From: Claire Townsend [REDACTED]
Sent: 14 December 2018 11:43
To: Sian Eggington
Subject: RE: AB/134/18/HH
Attachments: 37 Priory Road - PLANNING-03 V1.pdf

title:
Proposed Plans & Proposed Block Plan

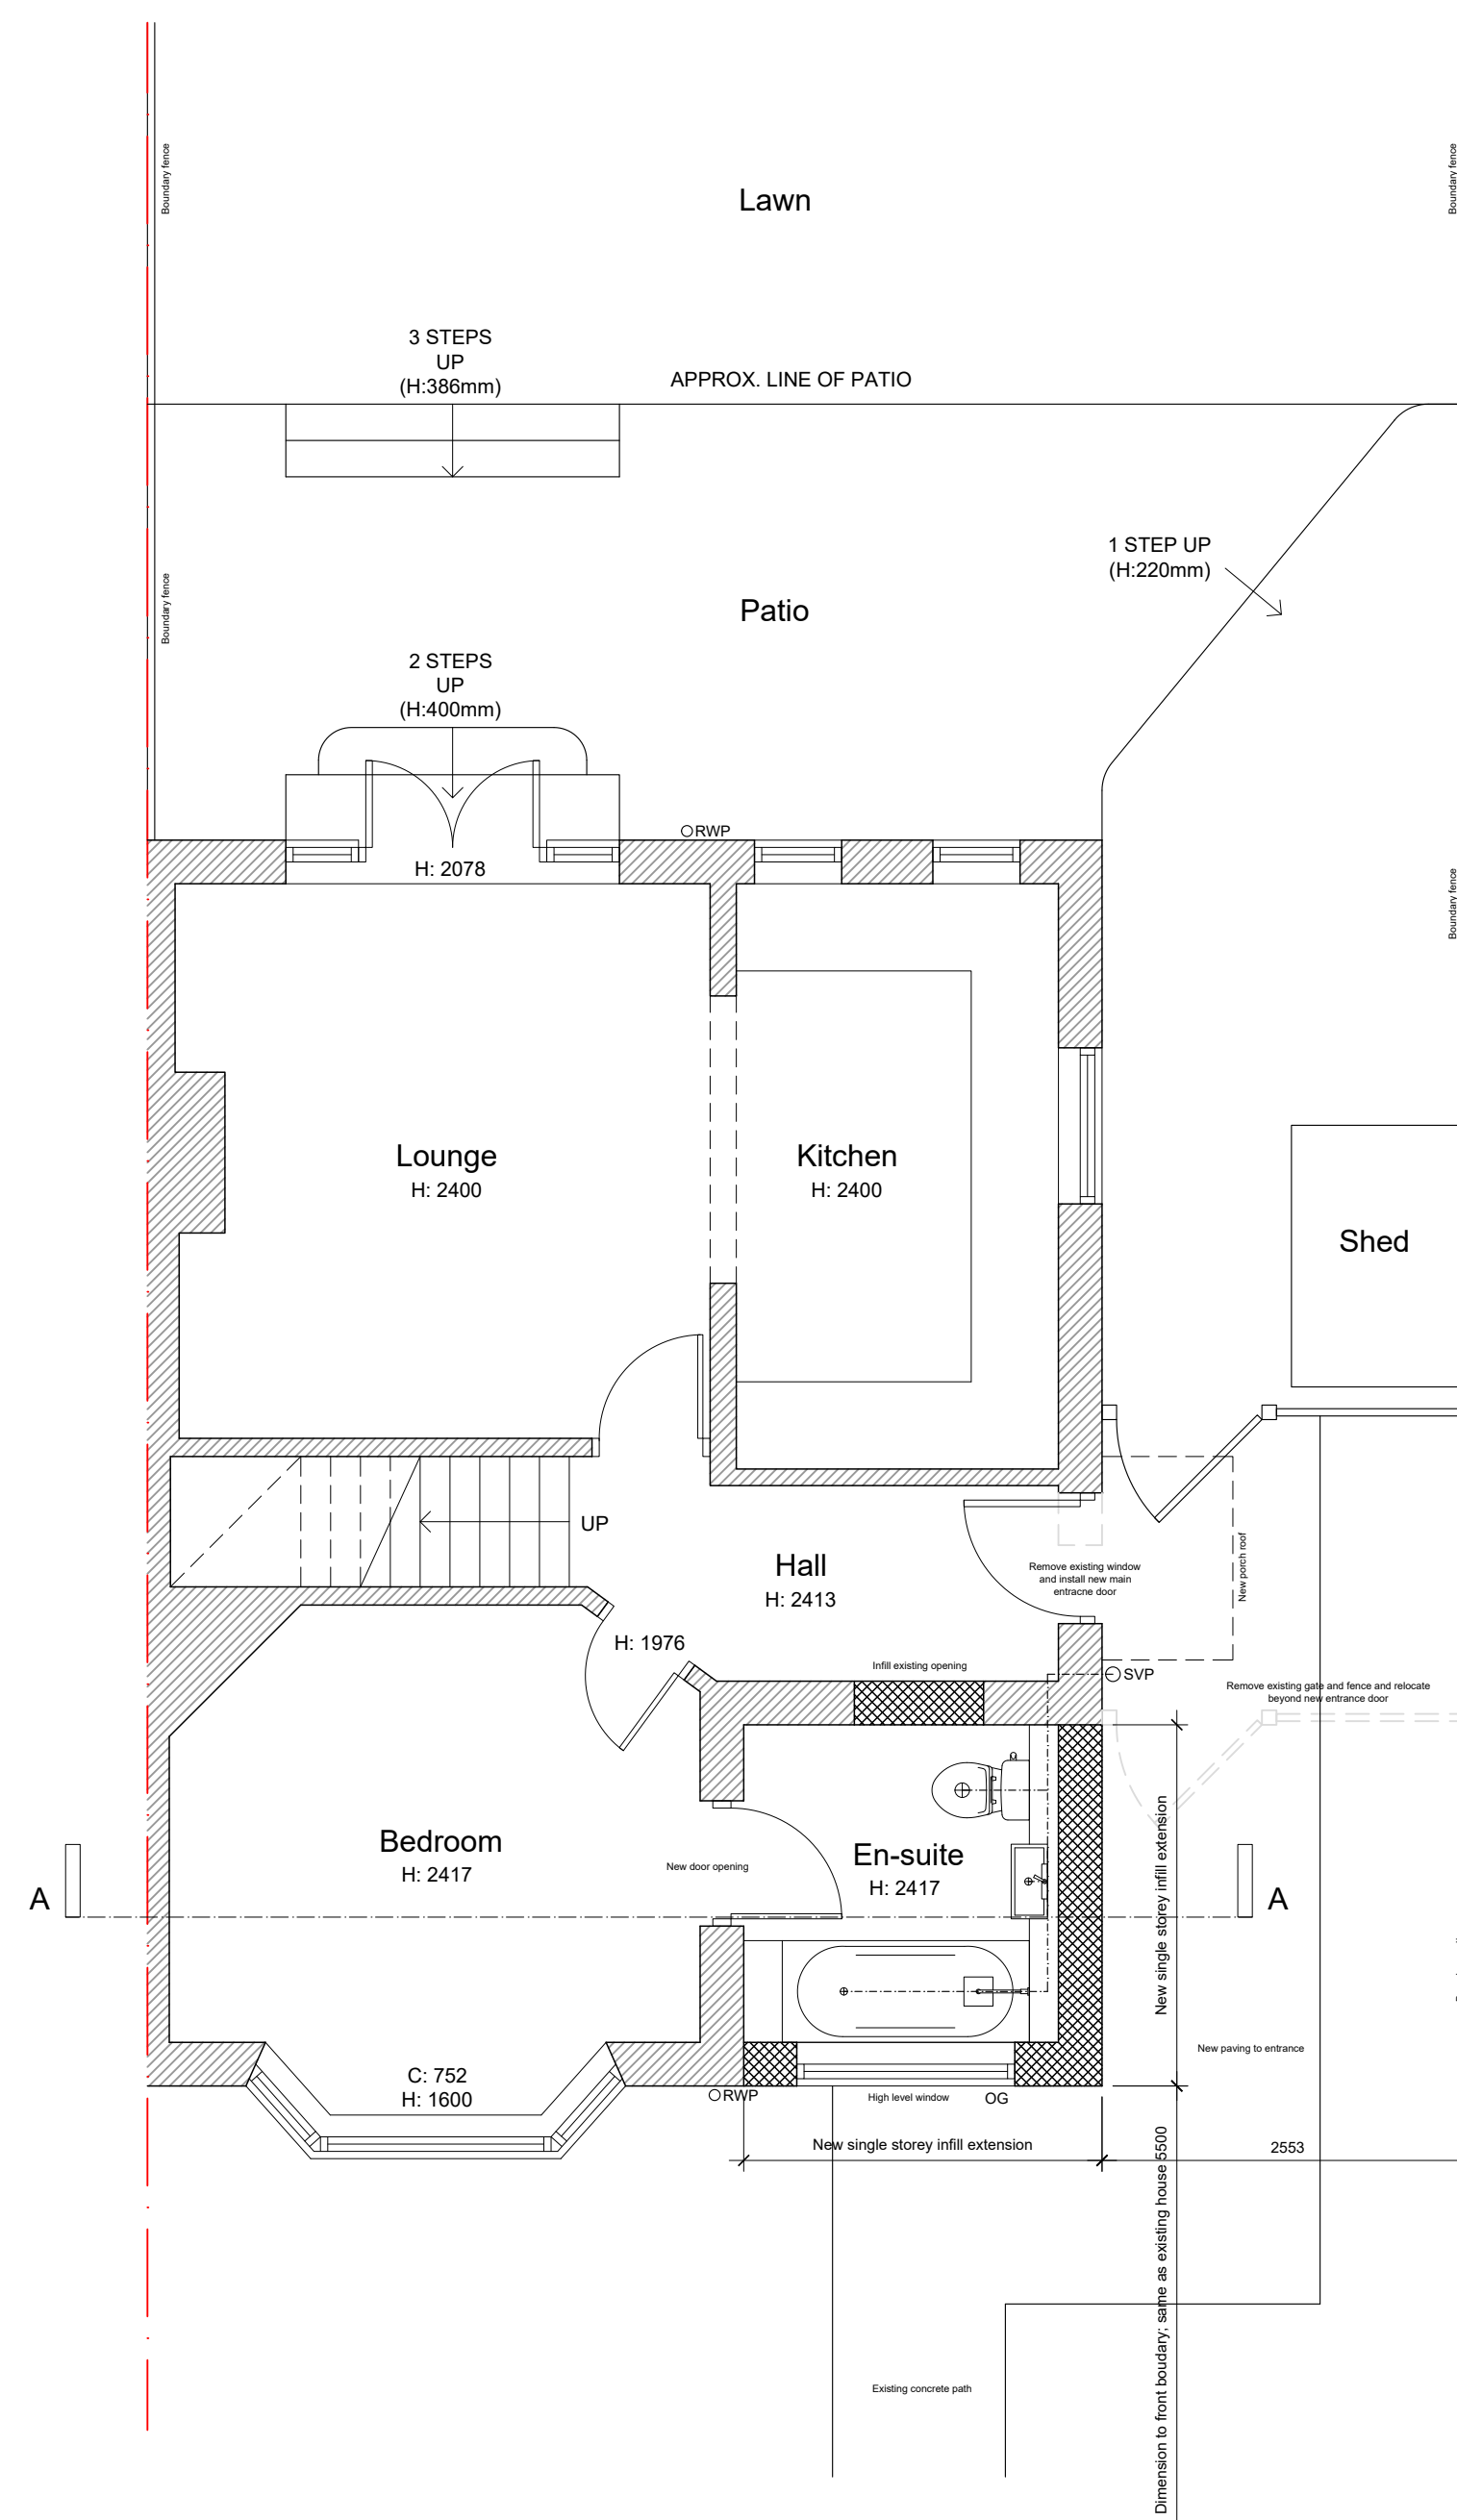
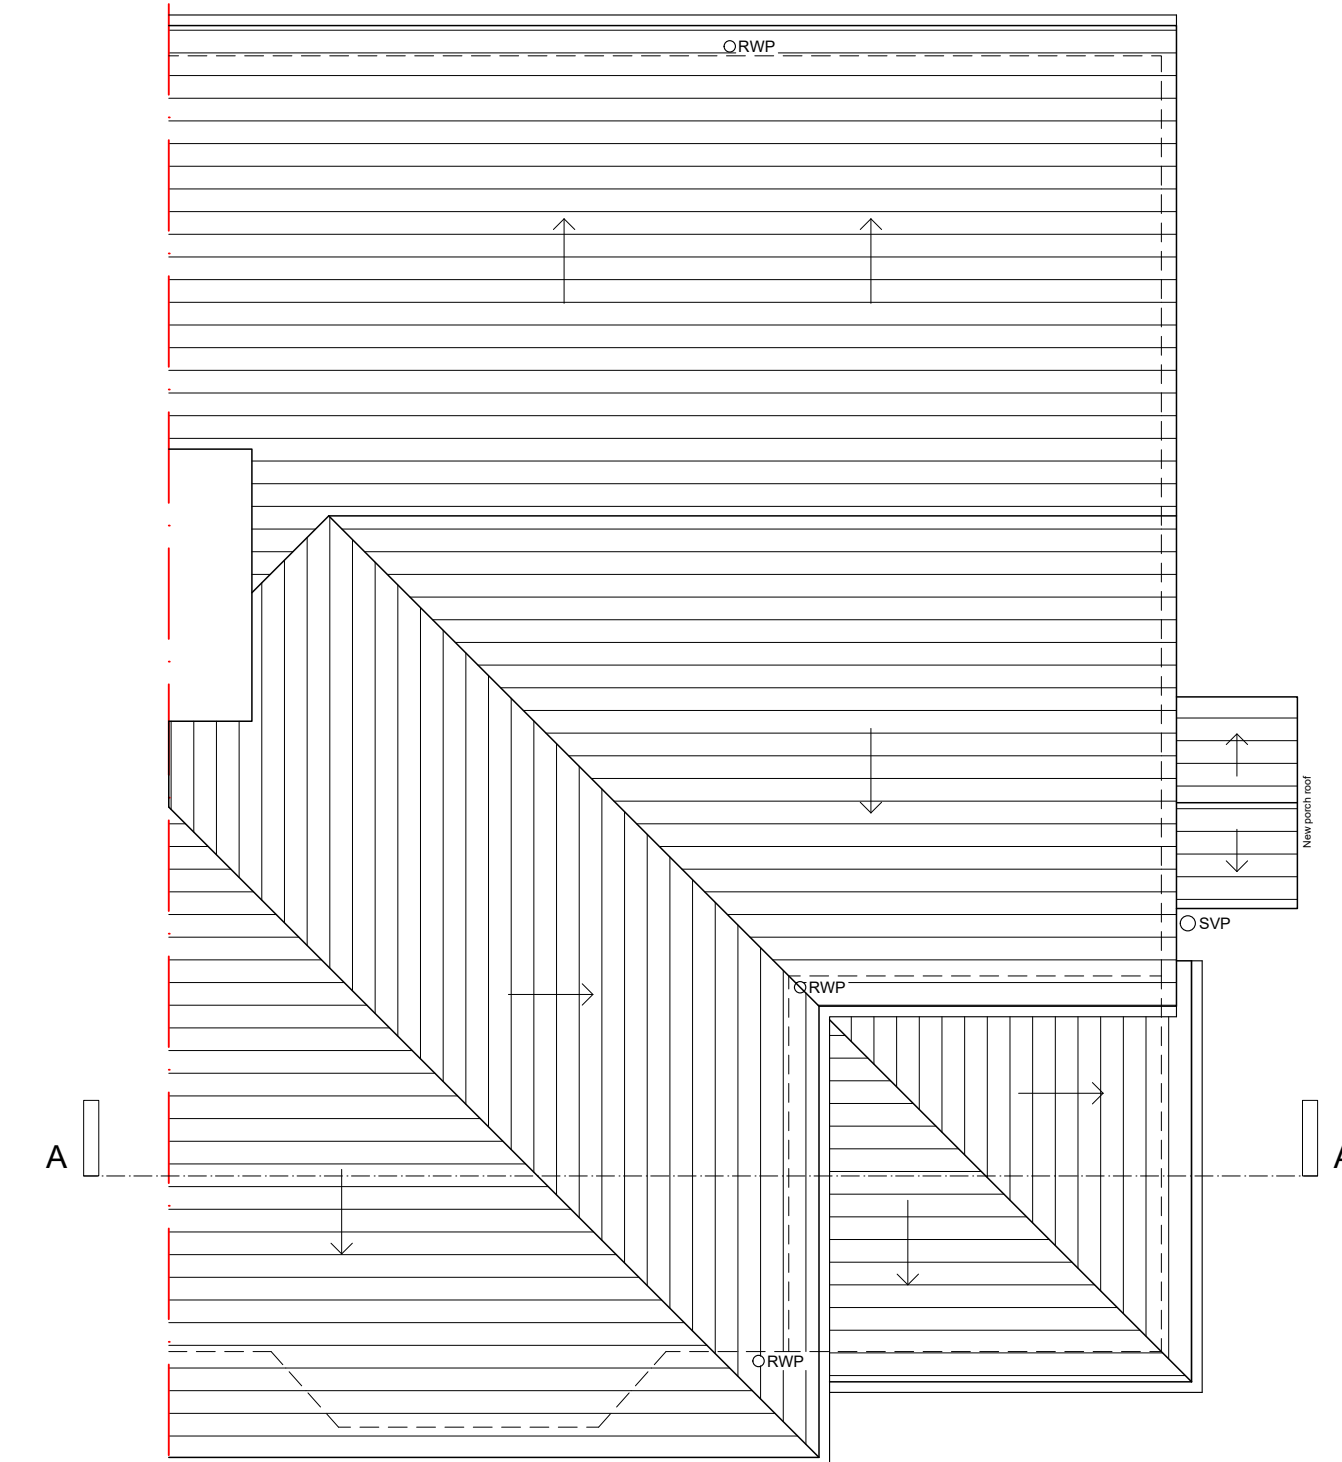
As the boundary is shown on the floor plan I am happy for you to show the side dimension to scale on the floor plan. However a local requirement for Arun council is that all dimensions are shown but as you have stated the extension is just an infill only a front and side dimension is required however for the front dimension if you just put a note by the floor plan saying 'the dimension from the existing house to the front boundary is ...' I will accept that. Once received I'm happy to make the application valid and get it uploaded for you straight away.

- The dimension '2550' on the block plan does not measure to the stated scale of 1:500. Please amend accordingly;
- An additional dimension is required on the block plan from the proposed extension to the front boundary.

Great, ok, please see attached revised as described.

Thank you for your comments.
The block plan is an OS map, and are not taken as 100% accurate, however the dimension given is the actual dimension taken on site.

Would you prefer me to show this dimension on the floor plans where the site boundary is depicted accurately, as surveyed?
